Recommendation Report for Planning Permission for Works or Extension to a Dwelling

REF NO: WA/84/19/HH

LOCATION: Berberis
London Road
Fontwell
Walberton

PROPOSAL: Installation of wooden fence and driveway gate to replace hedge

Scale:
1:50

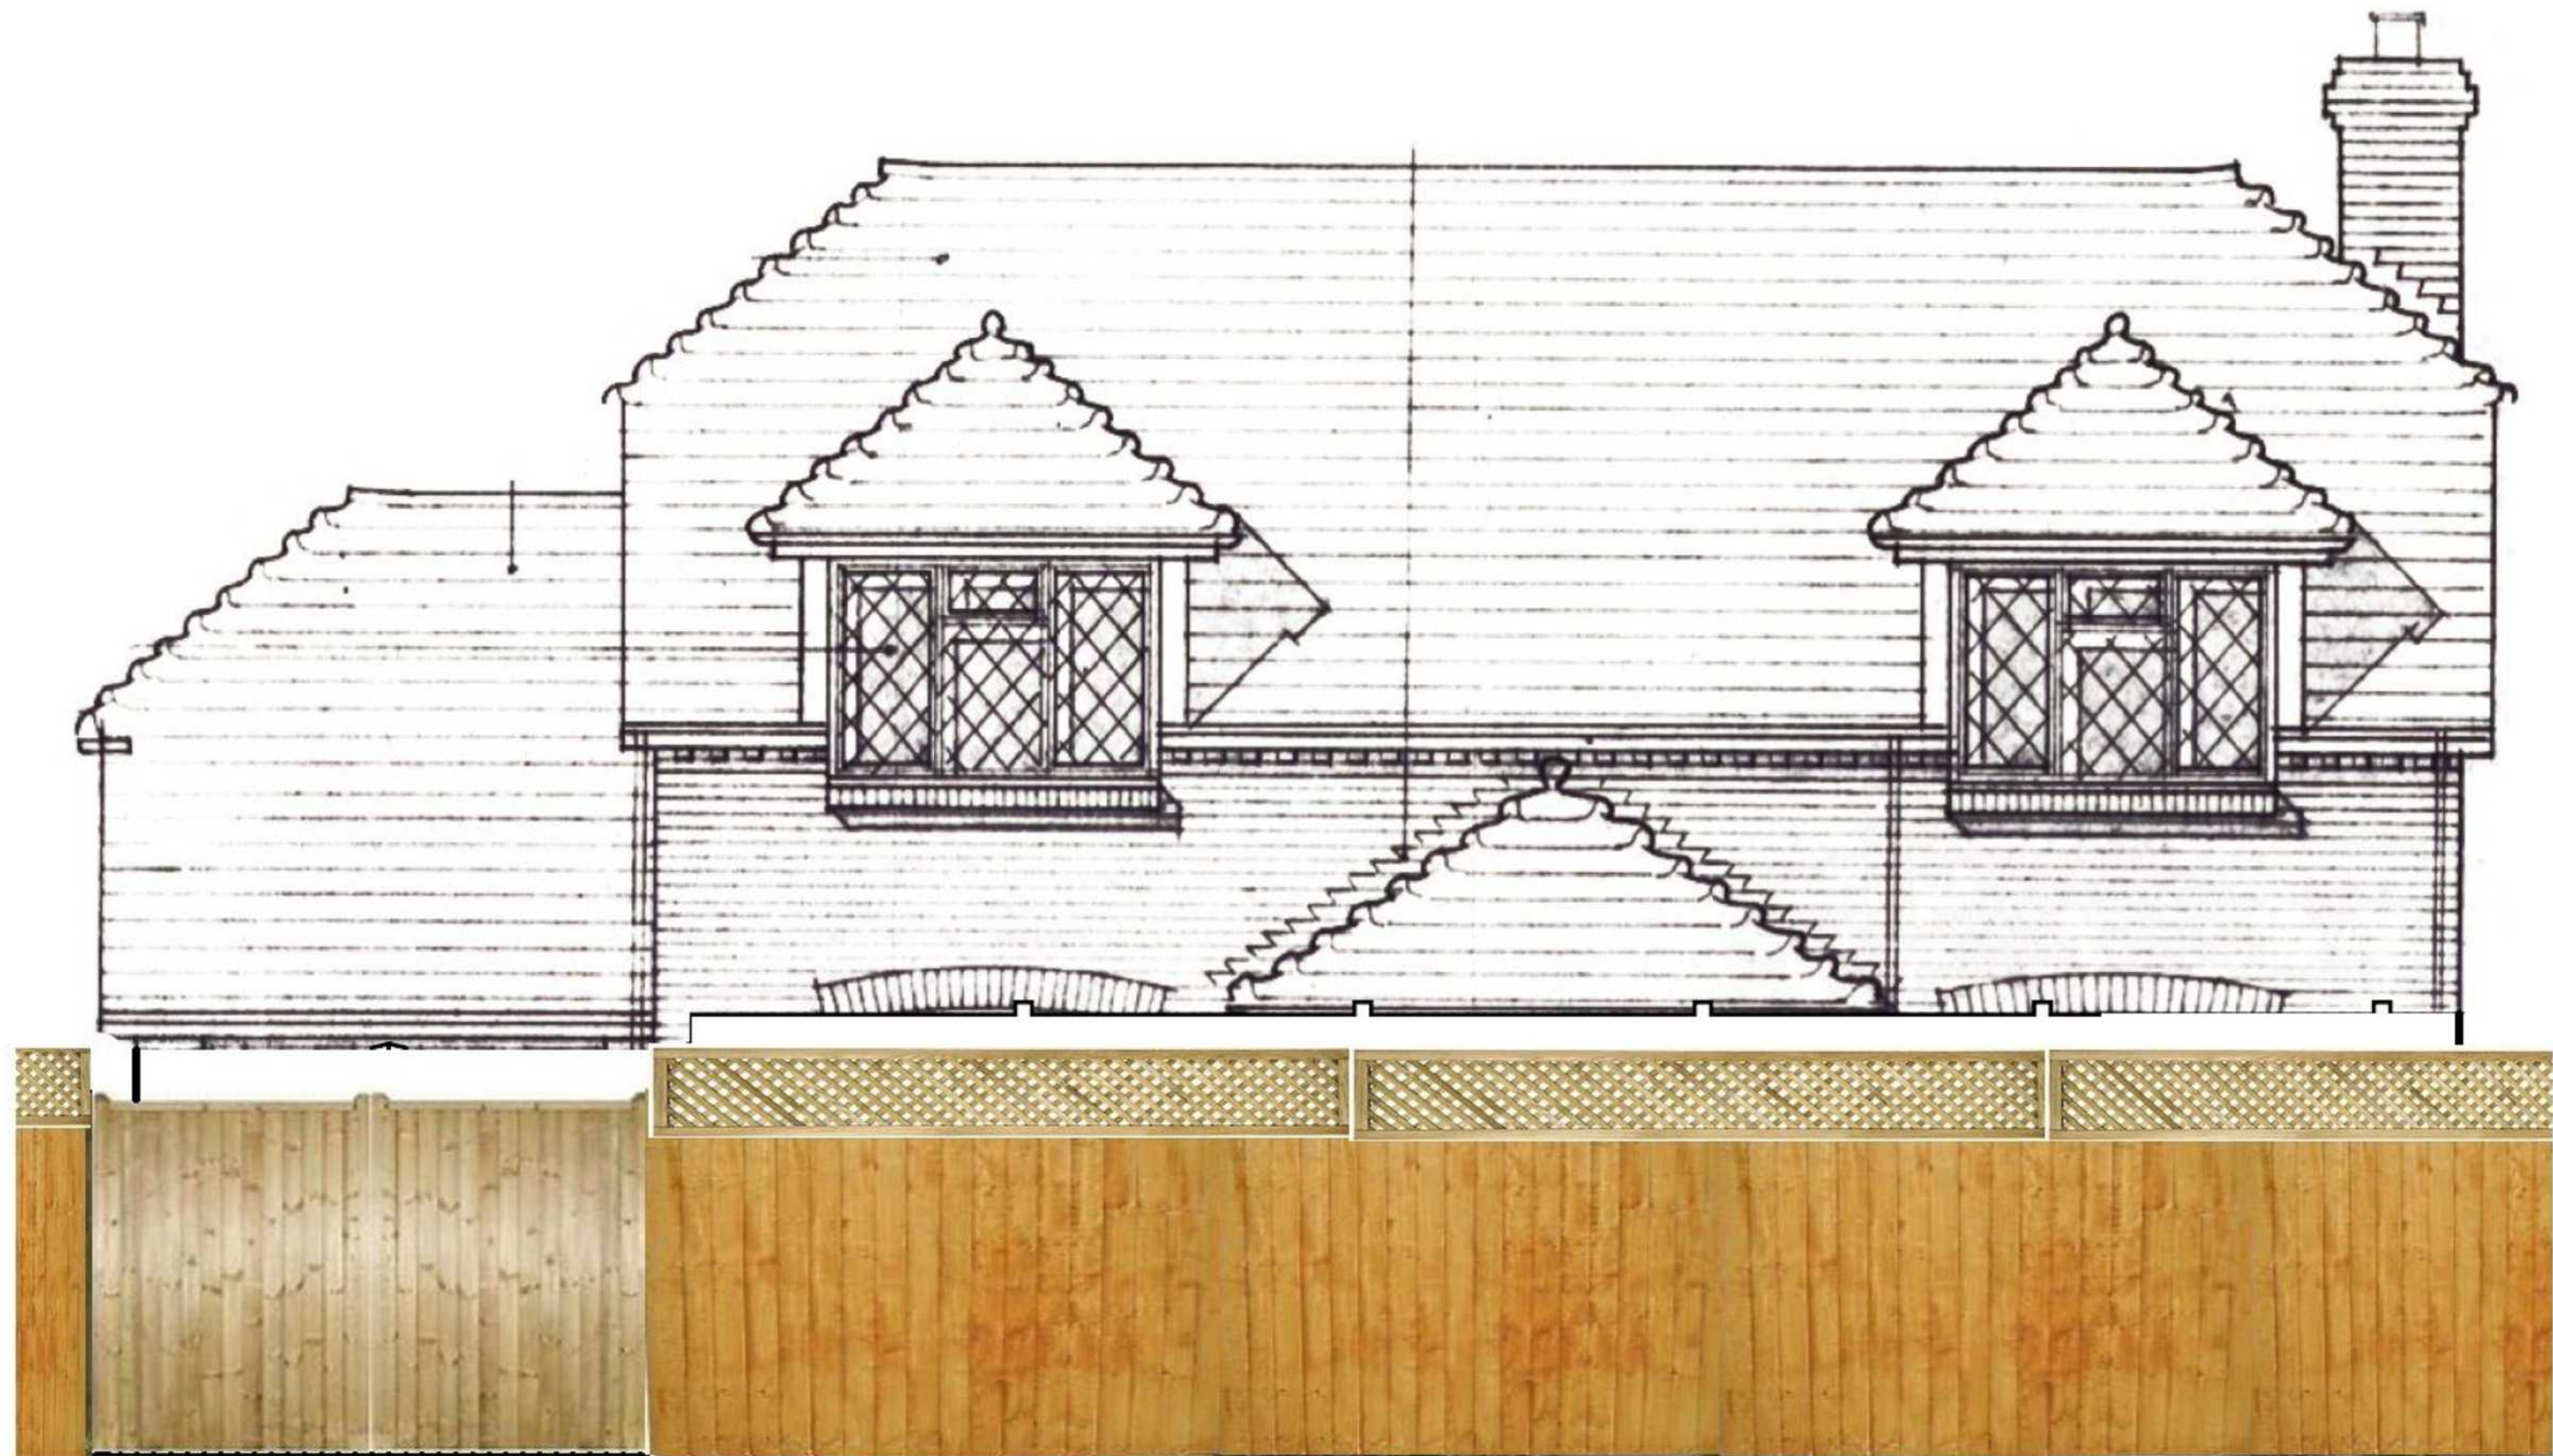
The proposal seeks to remove the existing hedge and replace with a fence of 1.42m in height with trellis to a height of 1.72m.

The fence will run along the front boundary for 15m with a gate included to allow vehicular access.

Whilst the wall is higher than the boundary treatment of most of the neighbouring properties, it is not considered to be so large that it appears unduly dominant and out of character with the surrounding area due to the proposed being set back from the site frontage and the climbers being planted to soften the appearance of the fencing. As a result it is not considered to significantly alter the appearance of the street scene and as such the proposal is in accordance with DDM1 of the Arun Local Plan.
